**WELWYN HATFIELD BOROUGH COUNCIL
EXECUTIVE DIRECTOR - PLANNING, PUBLIC PROTECTION AND GOVERNANCE**

DELEGATED APPLICATION

Application No: 6/2017/2746/LB
Location: Comet Hotel St Albans Road West Hatfield AL10 9RH
Proposal: Extension and refurbishment of the Grade II listed building (Use Class C1) following demolition of existing rear and side extensions. Erection of student accommodation (Sui Generis) with landscaping and associated works.
Officer: Mrs June Pagdin

Recommendation: Granted

DRAWING TITLE
Proposed Comet and Extension Ground and First Floor Plans

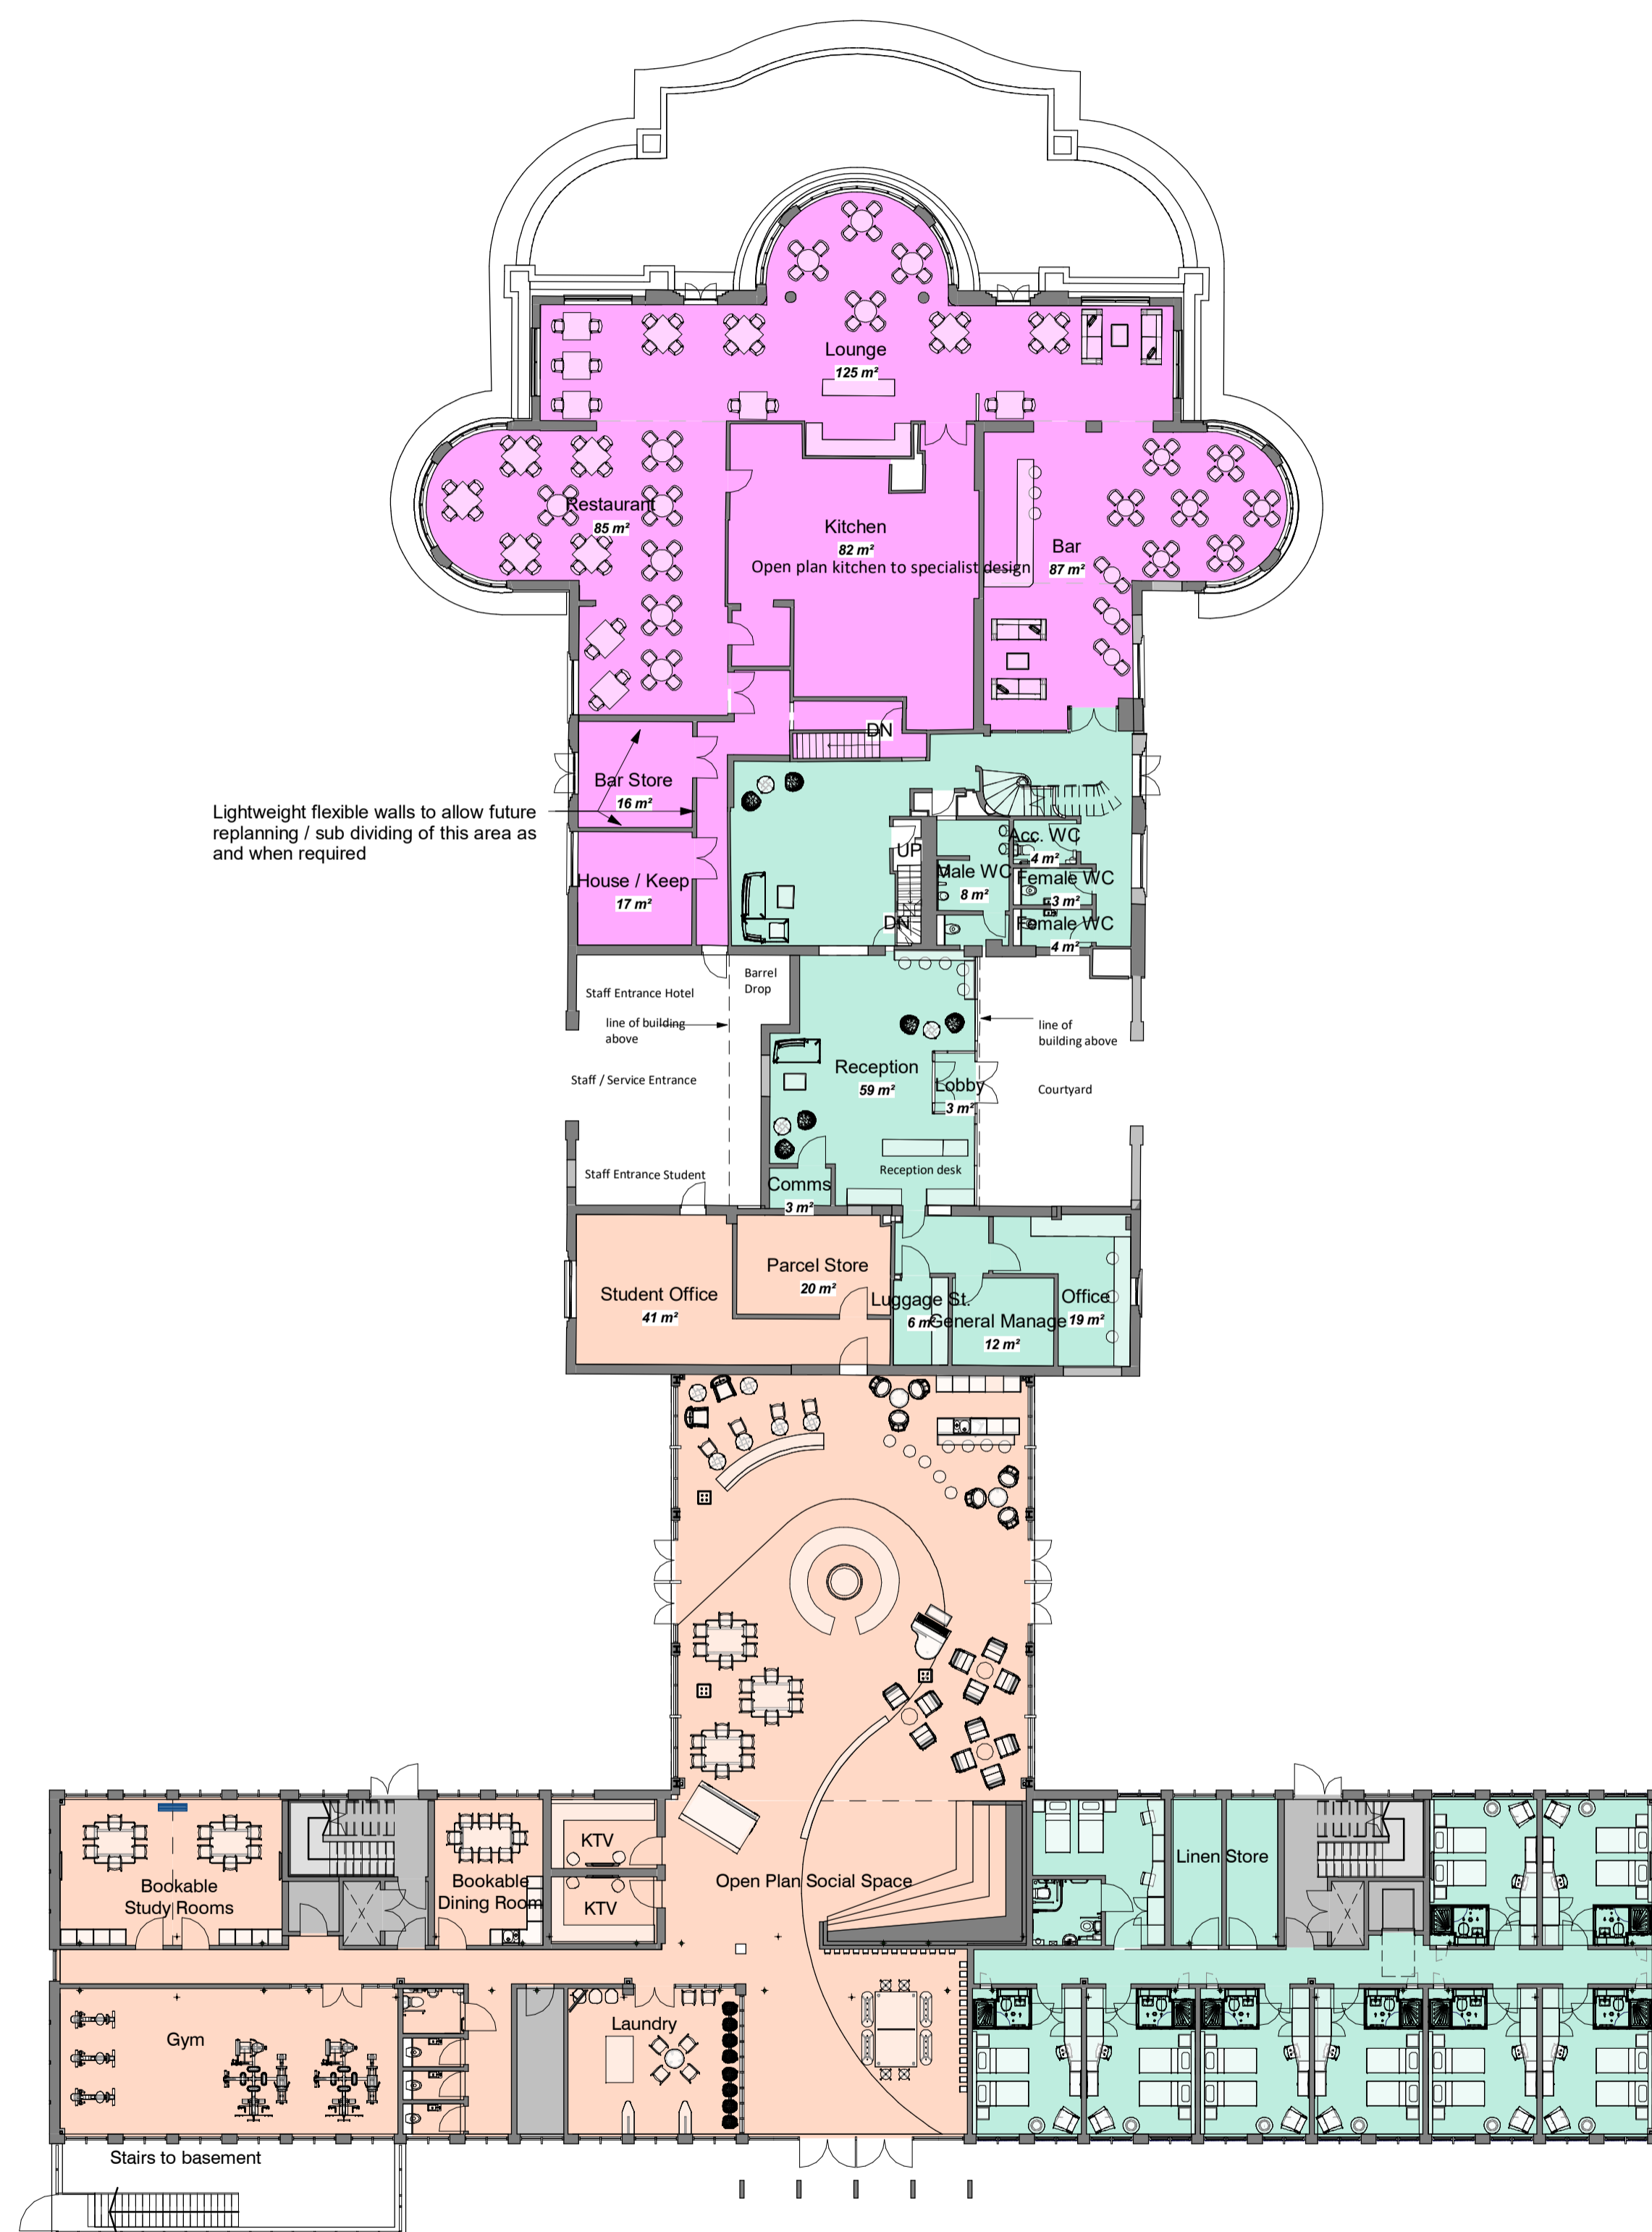
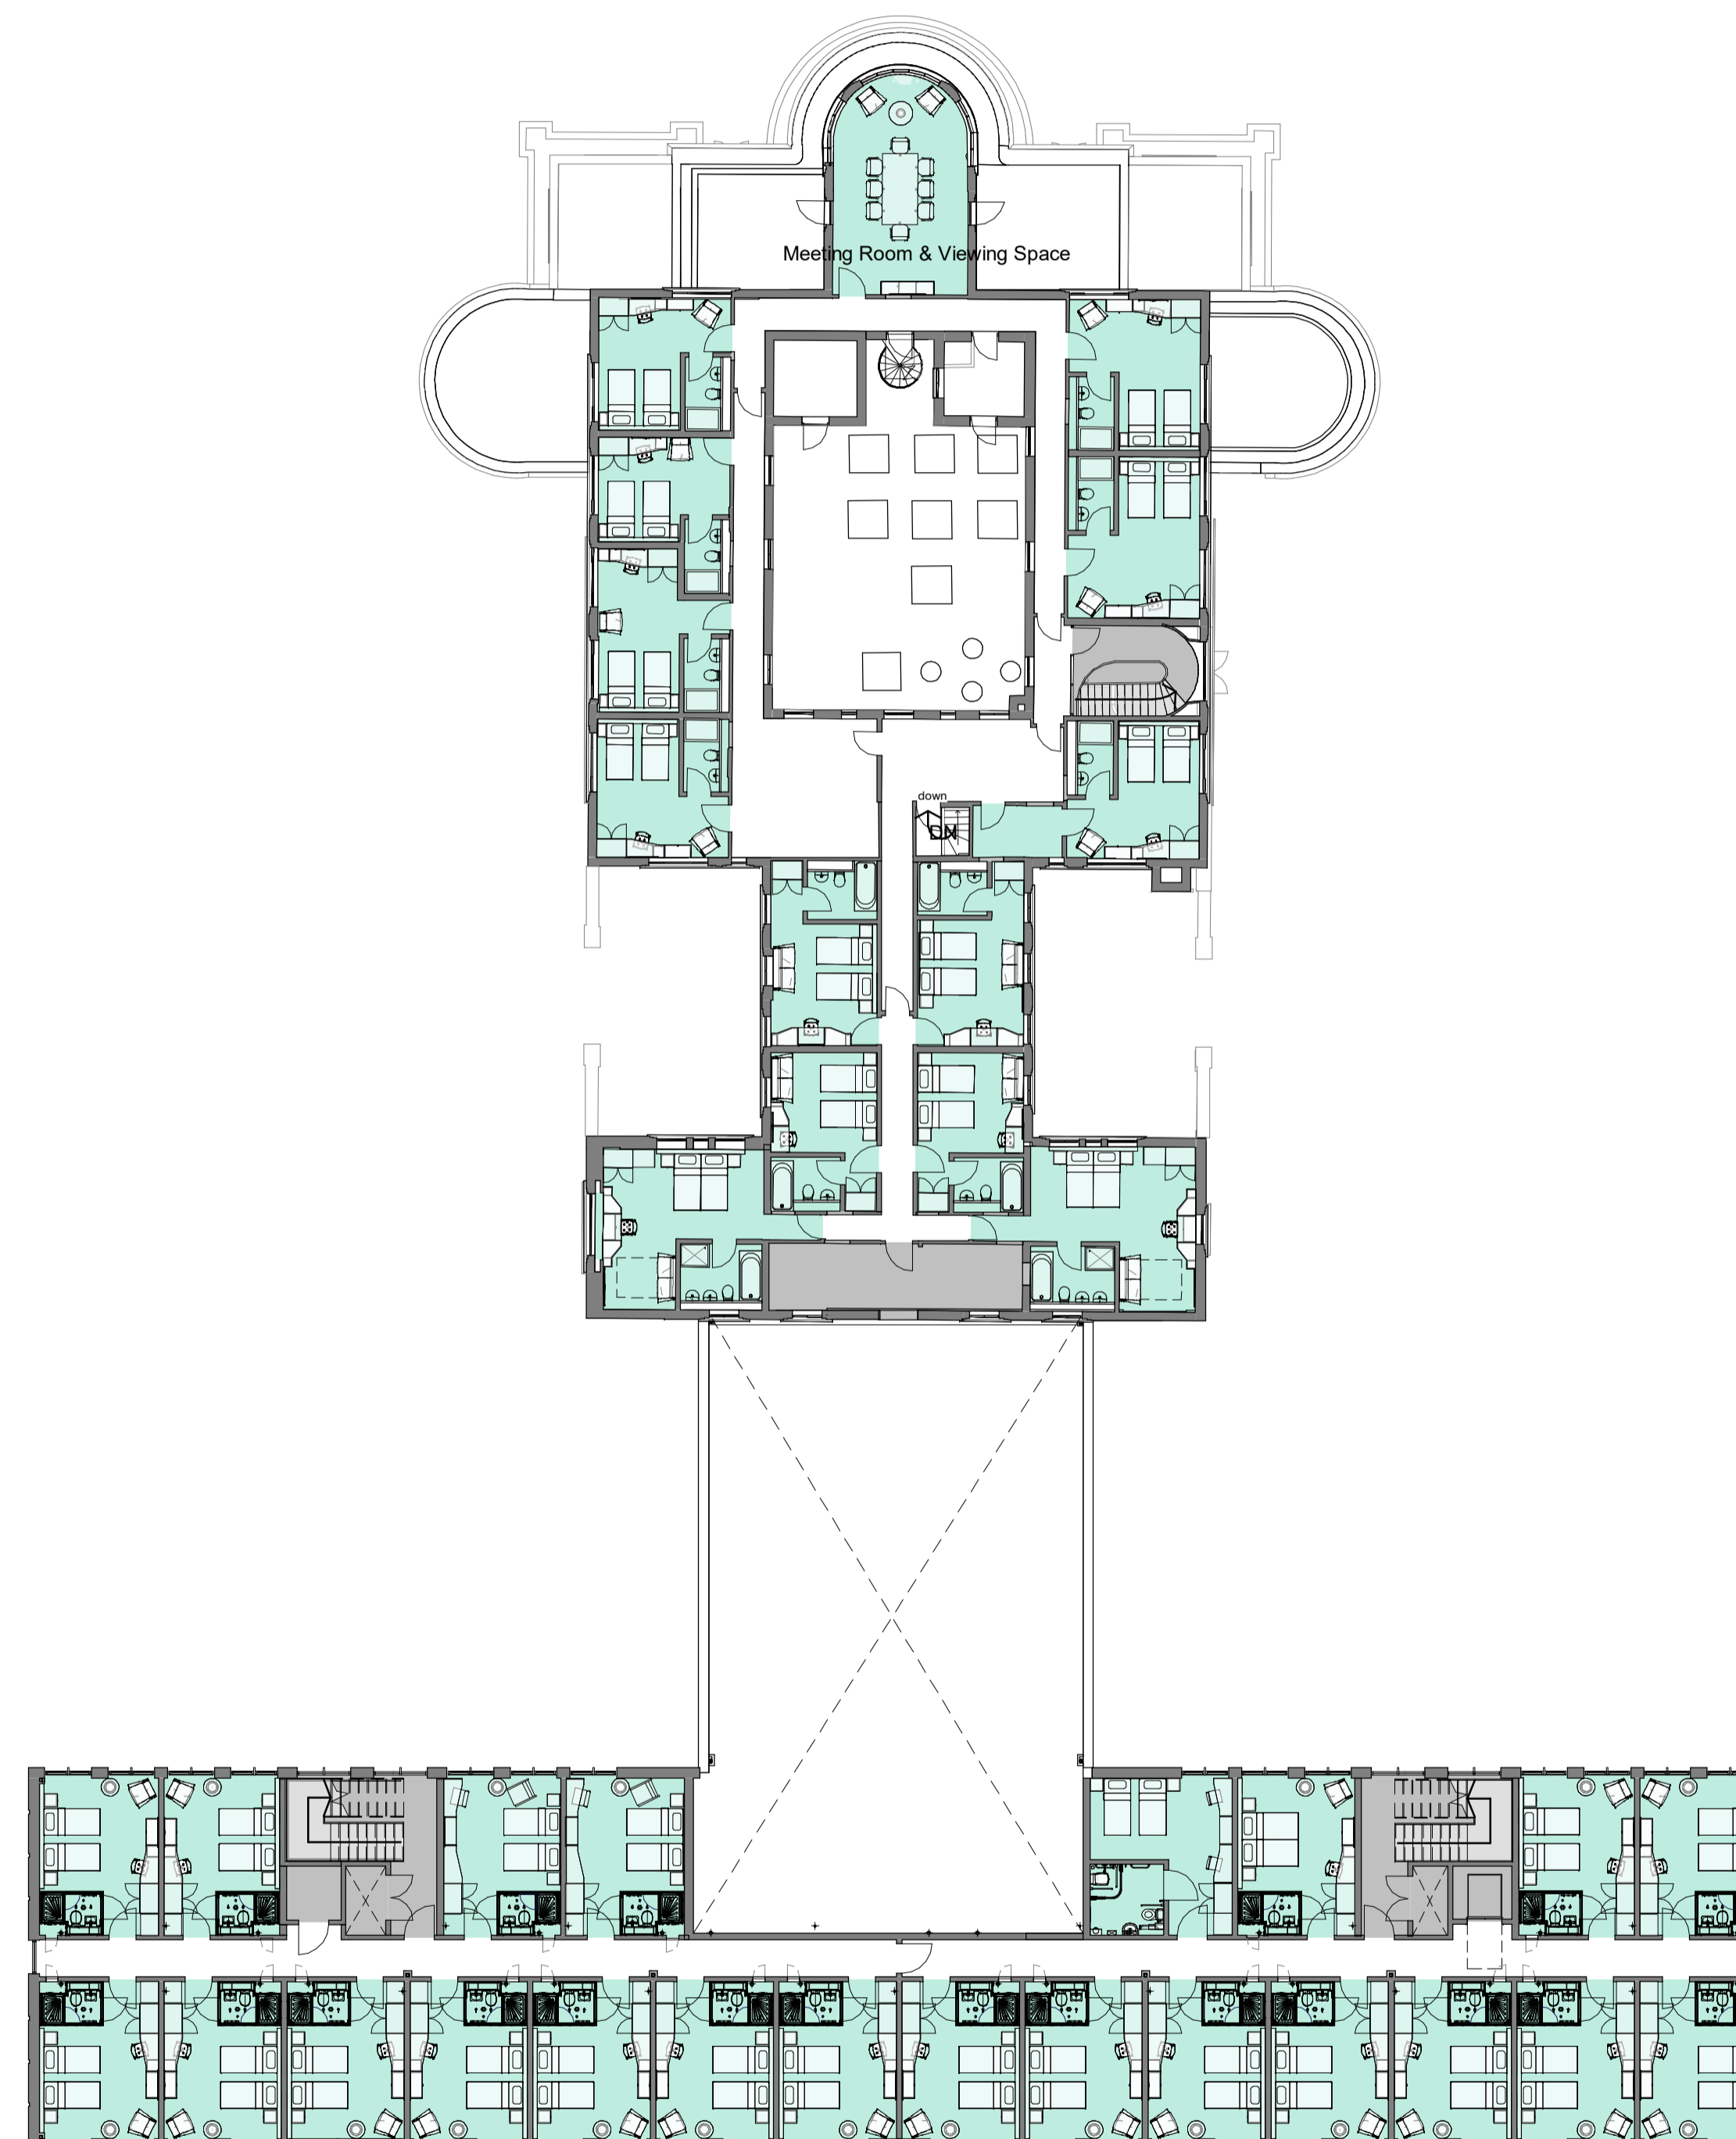
- The first floor would be used for bedrooms except for the front viewing room which would be a meeting room;
- The existing corridor widths would be retained;
- The spiral stair to the roof would be replaced;
- The ground floor reception area would be reshaped (not original fabric) to enable retention of the barrel run into the basement;
- Ground floor layout to be adjusted - lightweight partition walls to create bar store and housekeeping room;
- Nibs of original partition walls to be retained in restaurant area

The Heritage Advisor comments that the removal of surviving partition walls and the nibs of former partitions in the rear of the building where the garage and chauffeur quarters historically were would compromise the understanding of the historic plan form. It is recommended that nibs are retained as part of the scheme and exploration of this can be secured by condition.

The curved sitting room, which has access to the viewing terraces, on the first floor at the front of the building is one of the most important spaces in the listed building. A previous proposal to convert it to a bedroom with en-suite bathroom was not considered appropriate. Its retention as a public space makes a considerable contribution to its significance and is a positive element of the scheme.

The removal of corridor walls and storage rooms adjacent to this room is no longer proposed. The existing corridor configuration and width is to be retained and is considered to be a heritage benefit that would allow understanding and appreciation of the historic plan form. The retention of the barrel run as a functional feature is also considered to be a positive element of the scheme.

- a) reinstatement of roof lantern (elevations at scale 1:20 and sections at 1:50);
 - b) retention of nibs to walls in the rear part of the listed building which were previously the chauffeur and garage quarters (floor plans at scale 1:50);
